LANDSCAPE ARCHITECTURE DESIGN REPORT - ADDENDUM 02

New Primary School in Mulgoa Rise

APPLICATION NO. SSD-11070211

Drawing Title
LANDSCAPE SITE PLAN
SCALE: 1: 750 @ A3

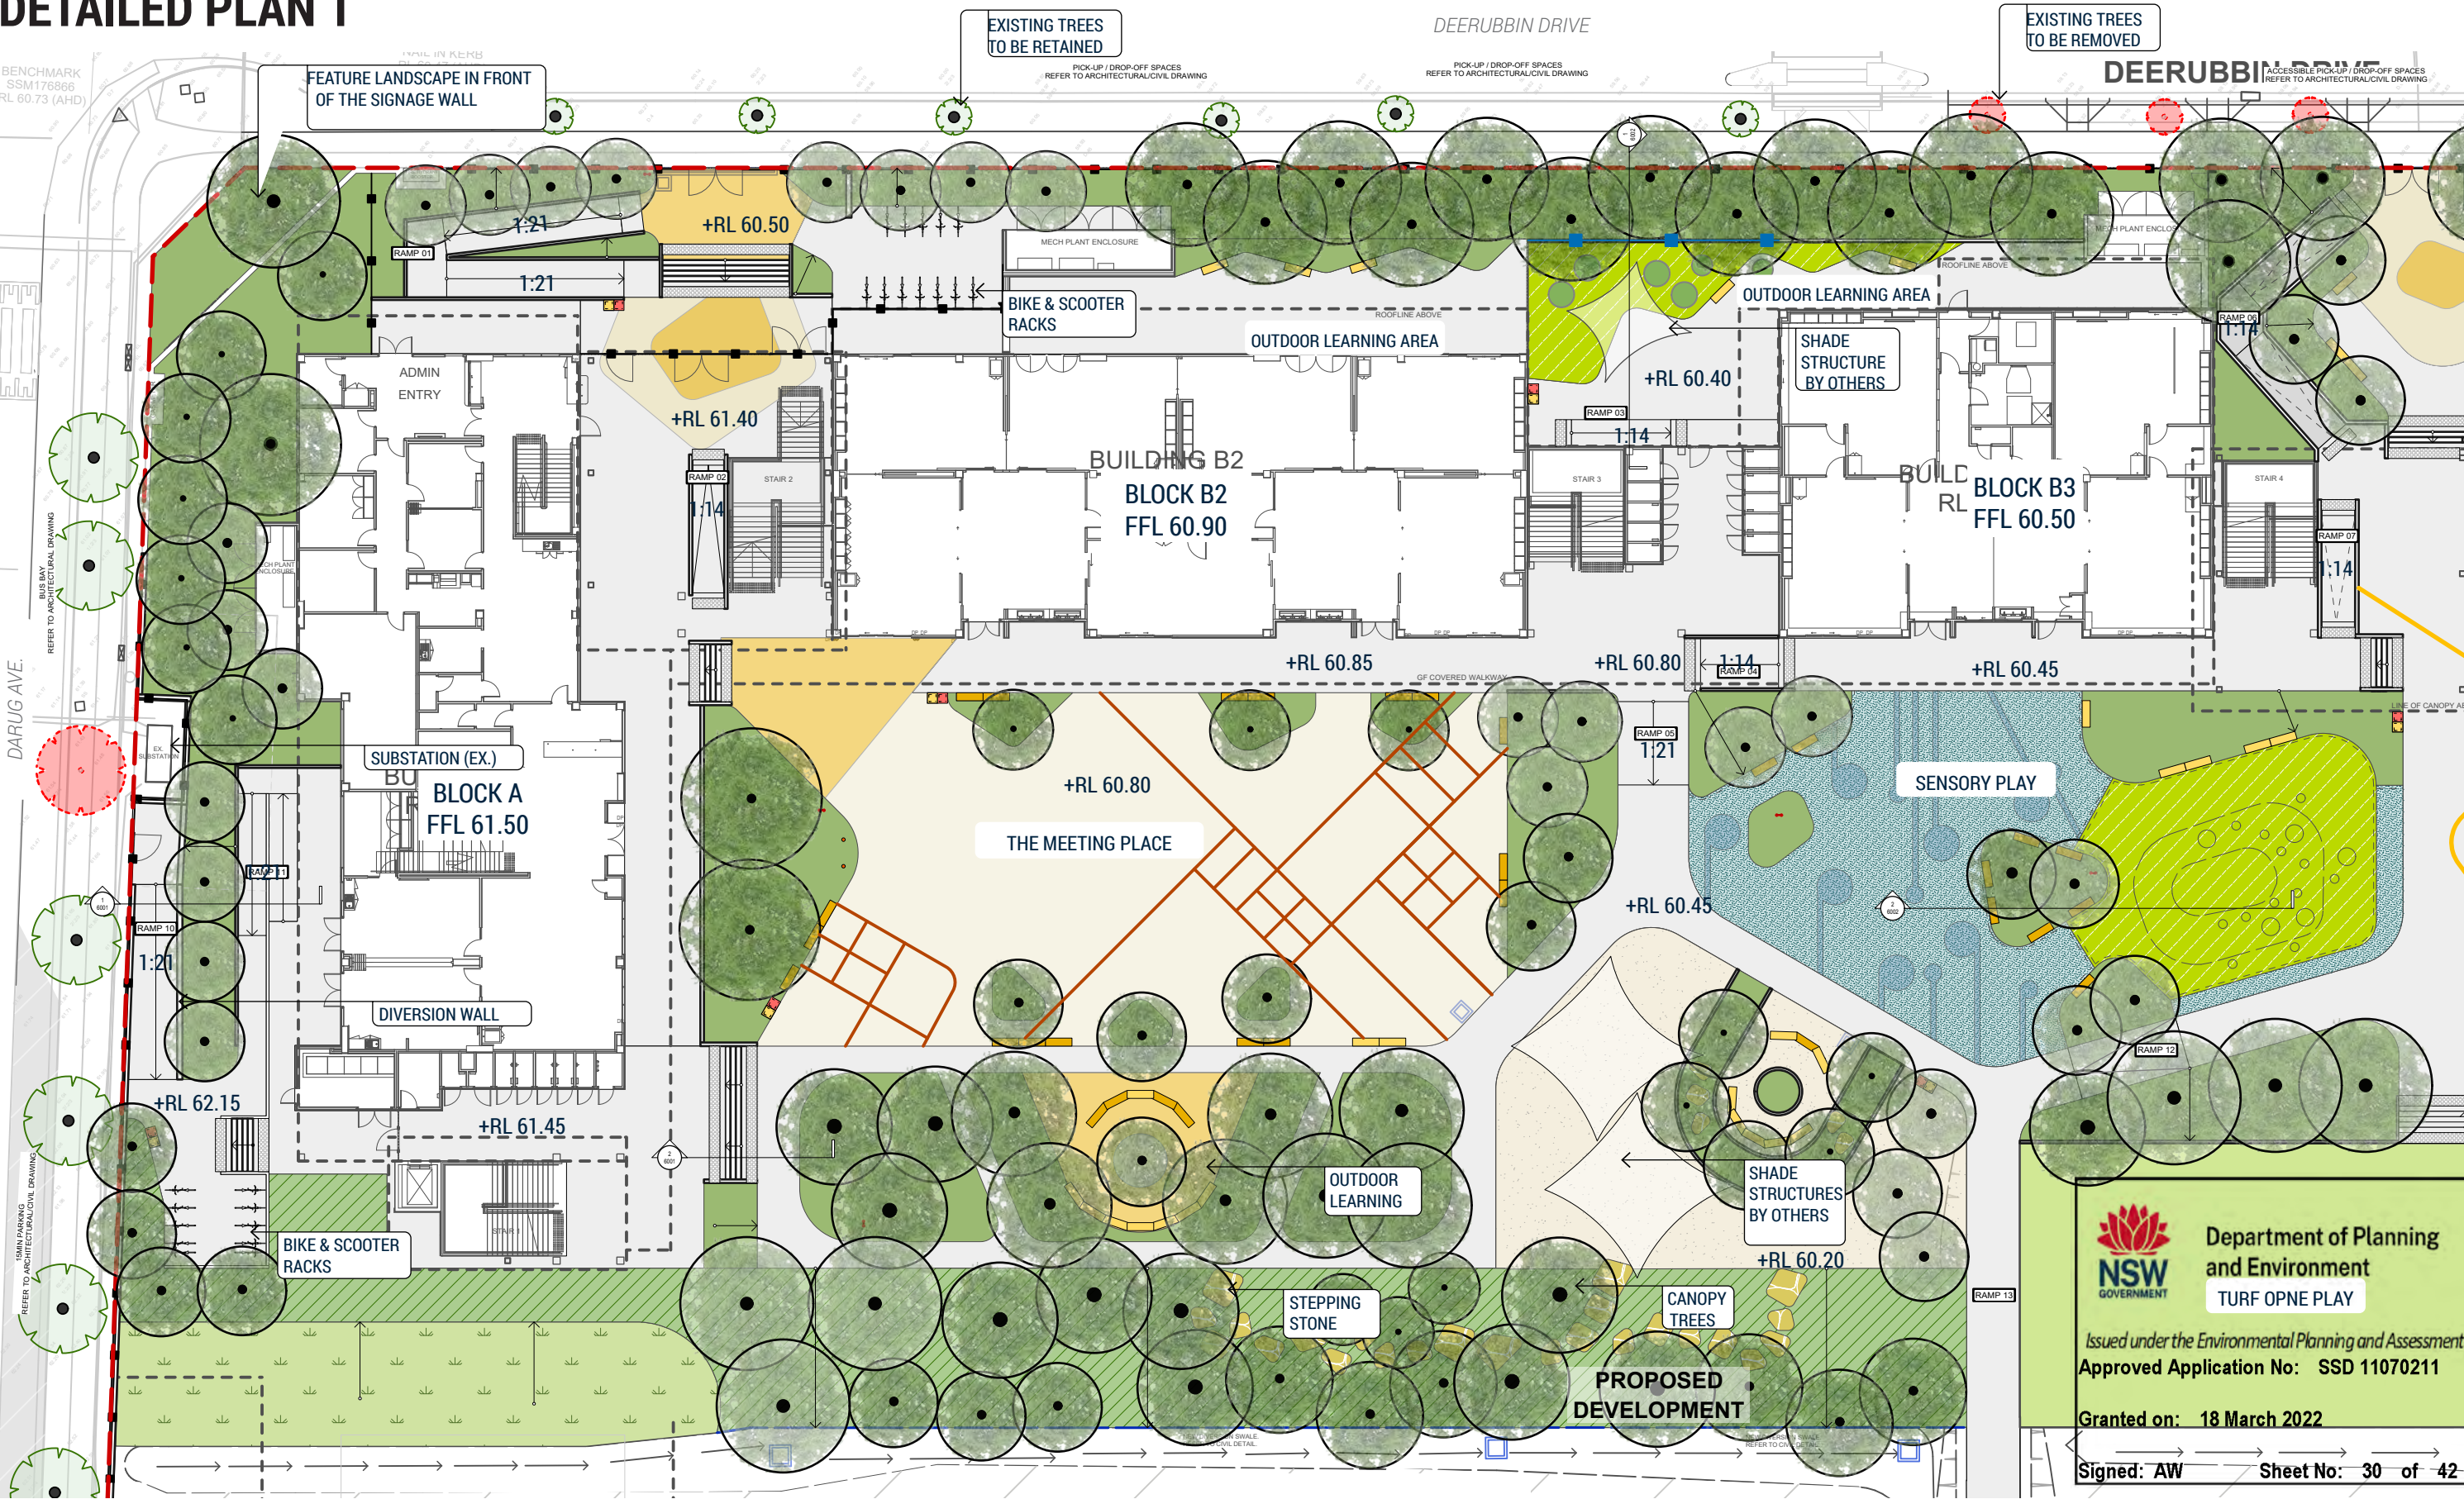
AGENCY	ISSUE	AGENCY RECOMMENDATIONS	REONSES
PCC	1. Planning Considerations	<p>P.2.1.(a)(i) The Department is urged to have strong regard to the need to ensure (in line with the Premiers Priorities and the Minister's recently issued Planning Principals), the need for high levels of canopy tree planting and green streets, Council raises that regard is to be had to Council's previous comments provided in cover letter dated 1 October 2021 including: (i) It is critical that planting within the front setback at this location is proposed where there are no street trees (also refer comments below in relation to street tree removal and recommended actions). The development of the site shall achieve and provide continuous canopy tree planting around the periphery of the development to screen the hard stand / manoeuvring area associated with the waste facilities.</p>	A continuous tree canopy has been provided to street frontages where possible. However there is an opportunity to provide a staggered tree alignment to further increase the tree canopy and screening, via adding 7 additional trees @ 100L pot size.

<p>P.10.4.(c) (c) Tree Canopy Cover There is a lack of detail regarding tree species and the corresponding canopy dimensions on the plan. Whilst the canopy cover appears to meet targets, large tree species are not identified on the plan, nor their mature canopy spread represented on the plan. Depending on the species and where they are planted, there is potential for tree canopies to damage building awnings or impact building maintenance regimes, and rootzones to damage paths and paving. Tree locations should be appropriate for the available volume above and below ground for canopies and rootzones respectively and the minimum 40% cover target would still be achievable. Assuming the unidentified open space along the access to Forestwood Drive is intended for parking, additional shade planting is appropriate to cast shade onto pavement areas. A kerb edge is required to contain parking to formalized carparks. Overflow and unauthorized parking in landscaped areas compromises soil compaction and tree health.</p> <p>P.12.4.(e) (e) Accessibility DDA compliant seating, incorporating universal design principles, should be provided in close proximity to accessible drop-off and pickup parking areas.</p>	<p>Drawing L-SSDA-0010 Planting Zone Plan provides the locations of tree planting across the site. This corresponds with the planting schedule provided on sheet L-SSDA-0011 Planting Schedule - Trees.</p> <p>The canopy dimension shown on plan is based on an average mature canopy dimension to account for variance in growth.</p> <p>Large canopy trees are located away from building awnings where possible to minimise the impact on maintenance.</p> <p>Correct the mulched area to the south of stage car park is intended to be a future extension of the stage 2 car park area. Tree planting has not been included in this area as tree planting in this area will be removed during construction of the stage 2 car park.</p> <p>A kerb has been included in the car park design.</p>

Drawing Title
PLANTING PALETTE

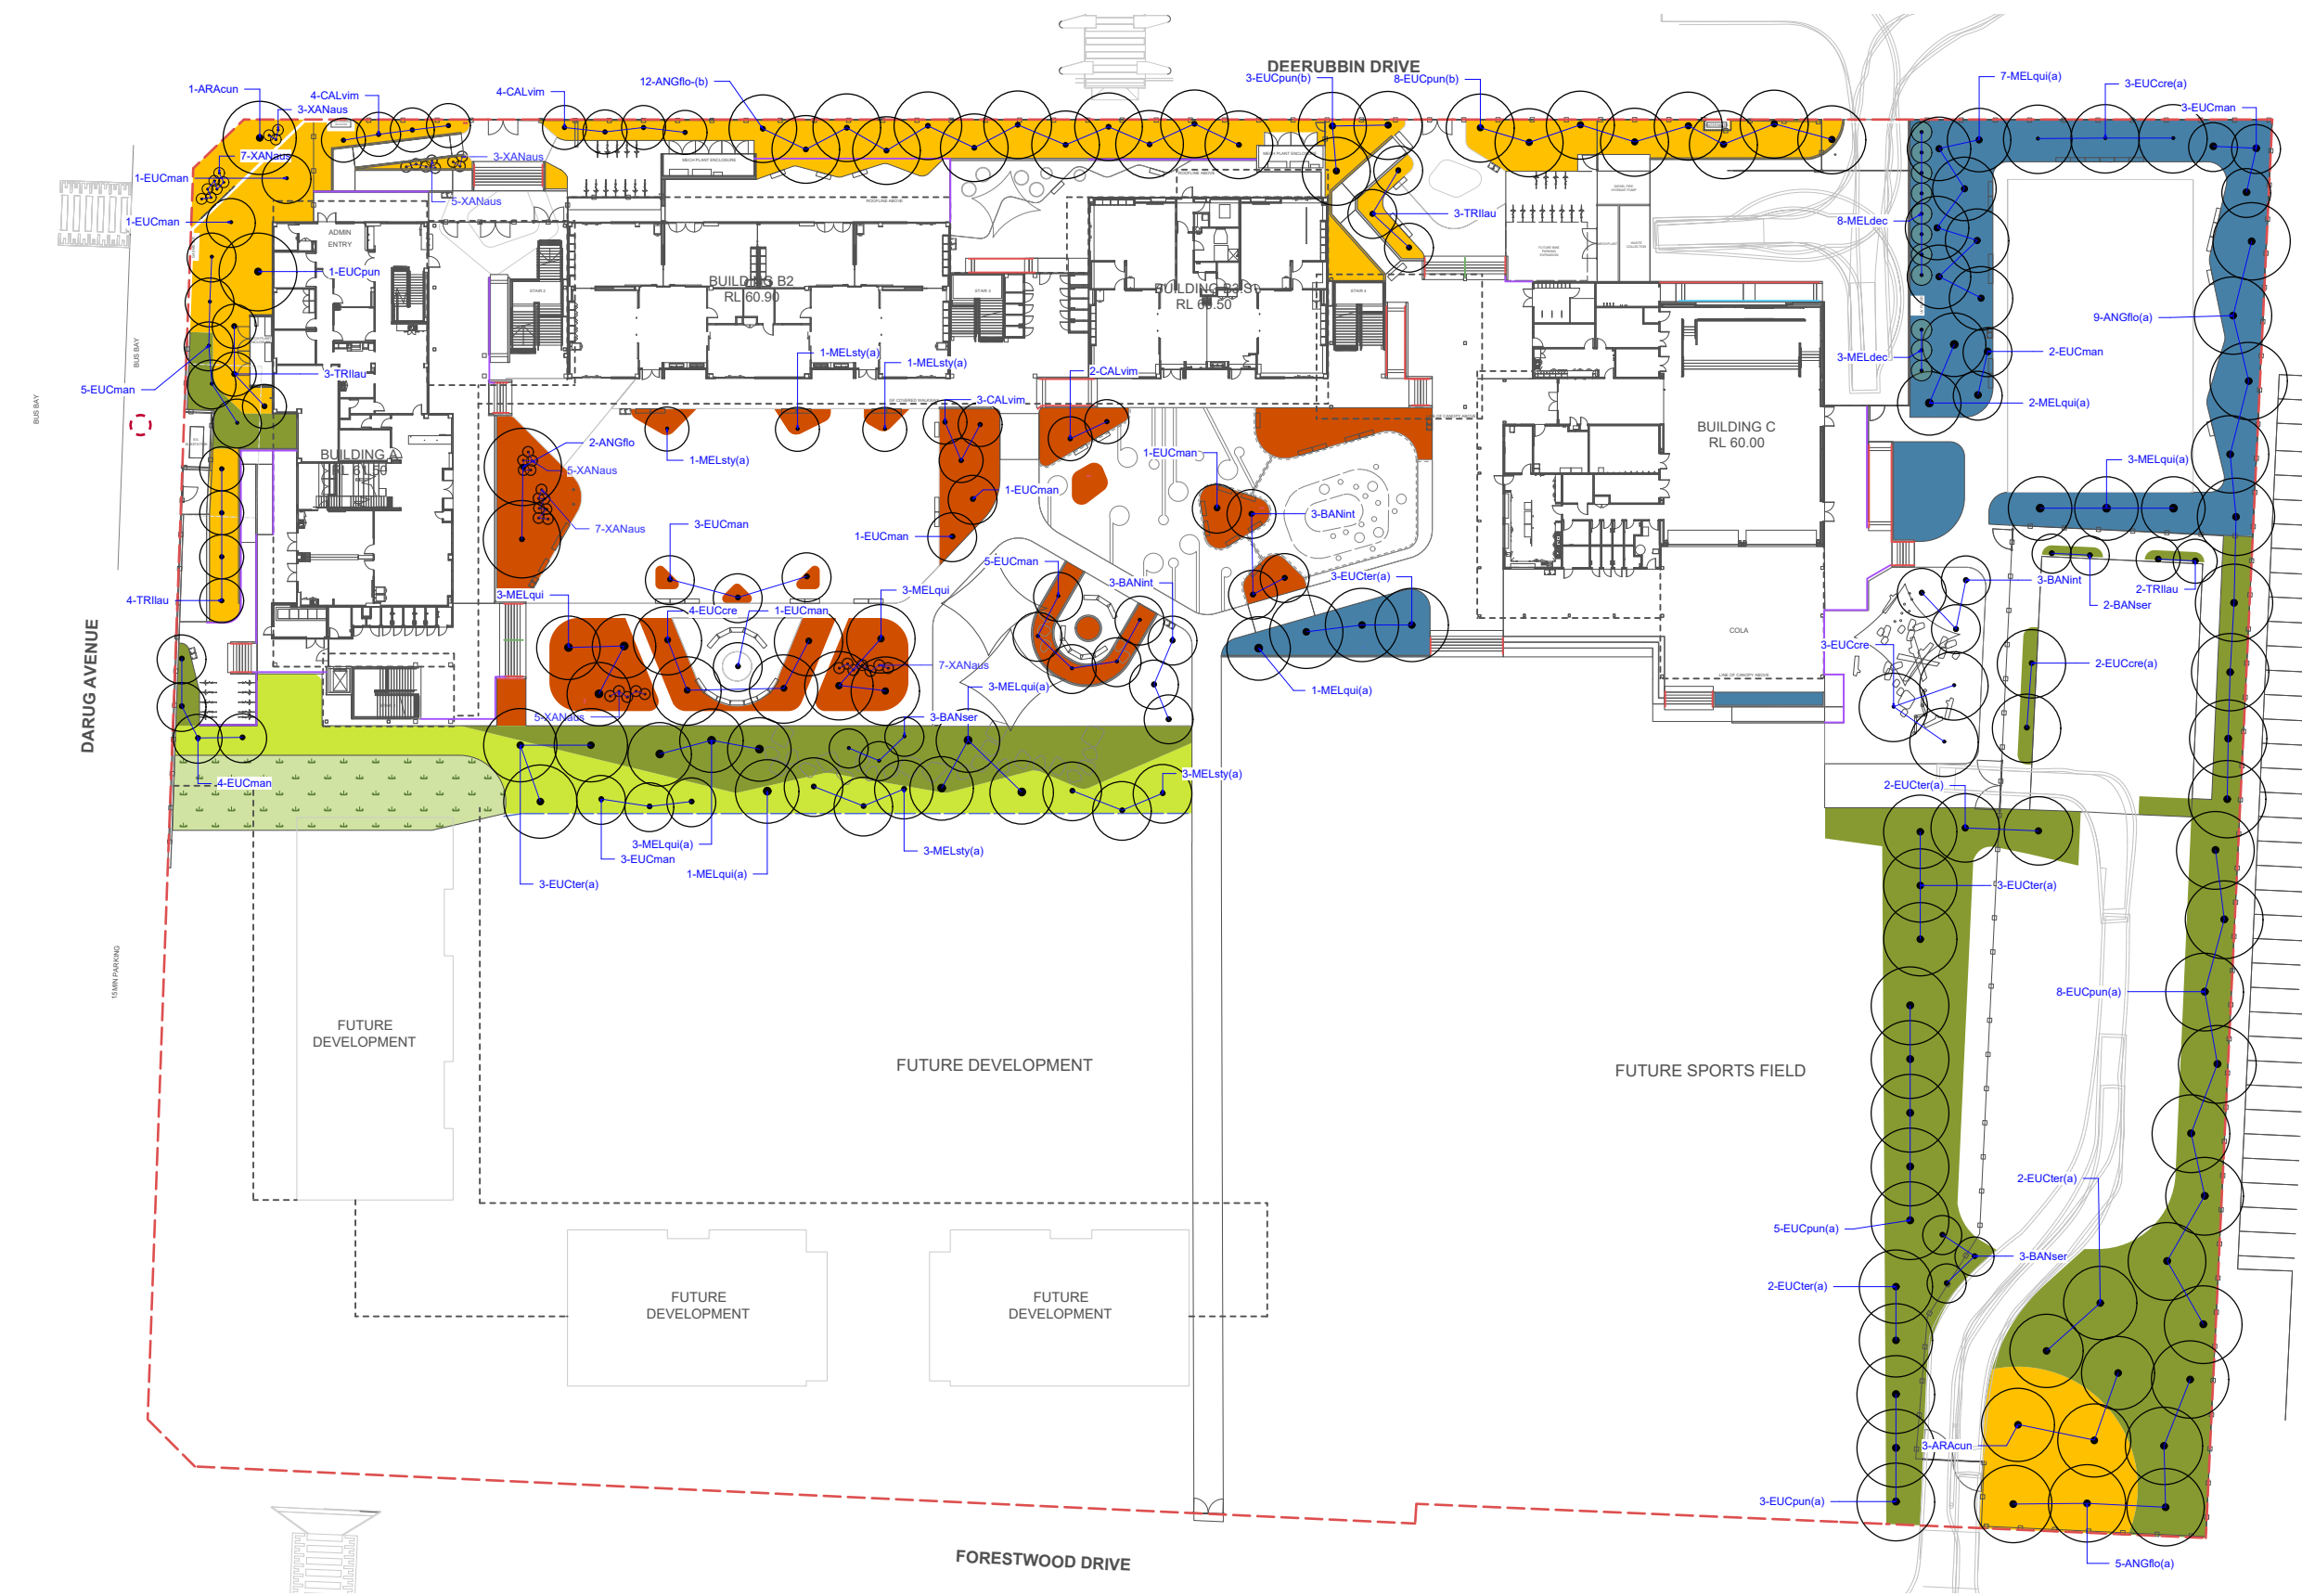
<p>EES</p>	<p>Site Landscaping / Habitat Improvement</p>	<p>E.1 Use of local native provenance species In its submission on the EIS, EES recommended the SSD uses a diversity of local provenance native species from the relevant native vegetation community (or communities) that once occurred on the site/locality, rather than use exotic species or non-local native species. EES recommended this particularly as the site is located near the Mulgoa Nature Reserve and Surveyors Creek Nature Reserve, both of which are mapped as containing biodiversity values. The EIS notes Mulgoa Nature Reserve contains good quality Cumberland Plain Woodland, which is listed as a critically endangered ecological community under the Biodiversity Conservation Act 2016 (BC Act), while Surveyor's Creek Reserve contains River Flat Eucalypt Forest, which is an endangered ecological community. EES also recommended in its submission on the EIS:</p> <ul style="list-style-type: none"> • The RtS and Landscape Design Report should identify the native vegetation community that once occurred on the site, or in the locality. • The Landscape Design Report should provide a list of local native species from the relevant vegetation community to be planted and demonstrate that the plant species to be used are of local provenance. • the Planting Palette and Planting Schedule in the Landscape Design Drawings are amended to use local native provenance species and identifies which species are local native provenance species and any non-local native or exotic species. 	<p>A updated planting schedule will be included to identify species from local plant communities. This will be also included in the report appendix C, L-SSDA-0011 Planting Schedule</p> <p>Planting palette images will be updated to reflect selected species. Exotic species have been removed from the design.</p>

<p>In response, the RtS states “where possible species from the local plant communities have been included in the design (subject to availability & EFSG requirements). To supplement these species local natives or robust native species have been selected to suit the site conditions”. The RtS does not specifically identify which native vegetation community once occurred on the site, or in the locality and it is unclear why the local native species need to be supplemented by other ‘robust native species’. EES notes in the RtS that Council recommended alternative tree species be identified that are more consistent with Shale Plains woodland. It is noted the Planting Schedule in Appendix C identifies plant species that are from Cumberland Plain Shale Woodlands and the Shale-Gravel Transition Forest Community but the Planting Schedule also includes numerous species that are not identified from these communities.</p>	<p>An updated planting schedule will be included to provide information regarding species locality plant communities.</p> <p>Native species from local planting communities will be prioritised based on availability & suitability for school environment.</p>

<p>Site Strategy and Landscape</p>	<p>EES repeats its recommendation that a condition of consent is included for any planting / landscaping associated with the SSD to use a diversity of local provenance native trees, shrubs and groundcover species (rather than exotic species or non-local native species) from the relevant native vegetation community that once occurred in this locality (see below). EES recommends an appropriately qualified bush regenerator is engaged by the proponent to provide advice on appropriate local native species that can be used on the site and to revise the Planting Schedule.</p> <p>E.2 Installation of Habitat Features EES recommended the school installs habitat features such as logs, a range of artificial nest boxes which are suitable for native fauna likely to utilise the site such as mobile birds and bats and bee hotels. The RtS notes reclaimed logs, boulders and the use of native trees have been included to provide habitable spaces, and that other habitat features will be considered where appropriate. EES recommends the installation of habitat features on the site is included as a condition of consent.</p> <p>E.4 Recommended Conditions EES recommends the following conditions of consent are included:</p> <ul style="list-style-type: none"> • Any planting/landscaping associated with the SSD shall use a diversity of local provenance native trees, shrubs and groundcover species (rather than exotic species or non-local native species) from the relevant native vegetation community that once occurred in this locality. • Tree planting shall use advanced and established native trees with a minimum plant container pot size of 100 litres, or greater for native tree species which are commercially available. Other native tree species which are not commercially available may be sourced as juvenile sized trees or pre-grown from provenance seed 	<p>The project proposes the Bush Regenerator Consultant to peer review NBRS Landscape documentation and provide a "compliance" statement.</p> <p>An updated planting schedule will be included to provide information regarding species locality plant communities.</p> <p>Habitat elements will be included and integrated into the landscape design. As no significant existing trees occur on site mobile bird & bats accommodation is not achievable (until trees mature). as such we have prioritised bug hotels, logs and boulders.</p> <p>Native species from local planting communities will be prioritised based on availability & suitability for school environment.</p> <p>Non local native have been included to supplement the local species as they are generally more robust for school environments.</p>
